Recommendation Report for Works to Tree(s) on trees subject to a Tree Preservation Order (TPO)

REF NO: BR/46/22/T

LOCATION: 43B Pevensey Road
Bognor Regis
PO21 5NY

PROPOSAL: Remove 4 lower limbs of 1 No. Corsican Pine tree.

43b PEVENSEY ROAD

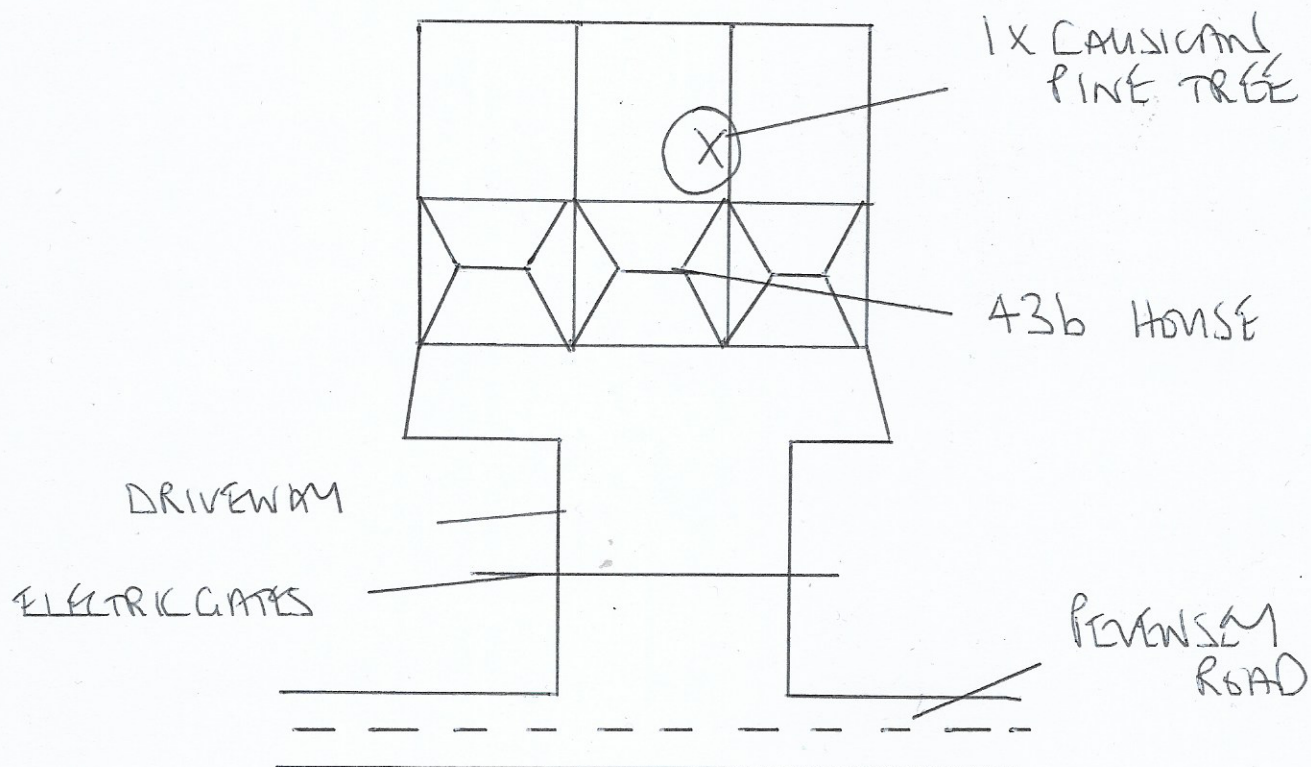
The lower crown profile is asymmetric although this does not detract from the tree's amenity value or present as a nuisance.

The removal of branches to balance the lower crown profile on all aspects does not meet the requirements in British Standard (BS3998:2010) Tree work - Recommendations. Such a loss in volume of needle-bearing branches would likely be harmful to the long-term health and vitality of the tree.

The tree is a significant feature in the local landscape and appears to be in adequately sound and healthy condition. The tree surgery proposed in the application is likely to result in excessive reduction of the tree's landscape impact and undue detriment to the visual amenities of the locality.

I recommend REFUSAL for this application
